Application No: K/55/20/PL
Site Address: 57 Coastal Road Kingston BN16 1SN
Description of works: Demolition & erection of 1 No. dwelling. This application is in CIL Zone 4 and is CIL Liable as new dwelling.

Thank you for your internet representation made on 21st December 2020 which has been recorded as an objection with the comments as follows:

West Elevation

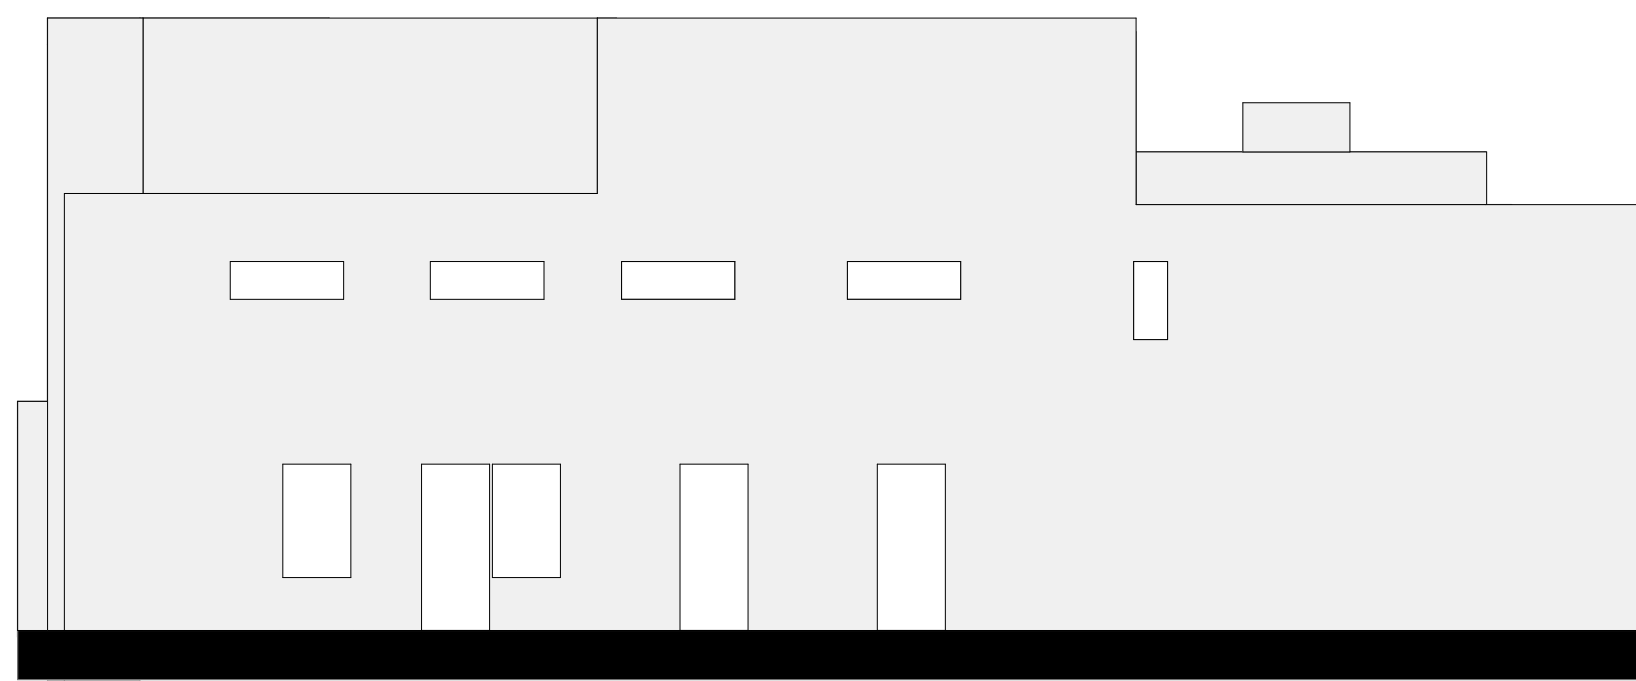
As with the previous application in 2018 we object very strongly to the size and scale of the whole planned proposal as it will affect all adjoining properties and the whole road scene. The footprint is enormous and more than twice the size of our property. As well as this the applicant wishes to extend the southern building line beyond the previous application. This is very detrimental to ourselves but also sets a bad precedent as it is out of keeping with all other properties.

The proposal will affect our privacy light and is totally overbearing. This is a particularly unneighbourly application due to it's scale but also because of the property size it will most likely be used commercially as a large scale holiday letting operation.
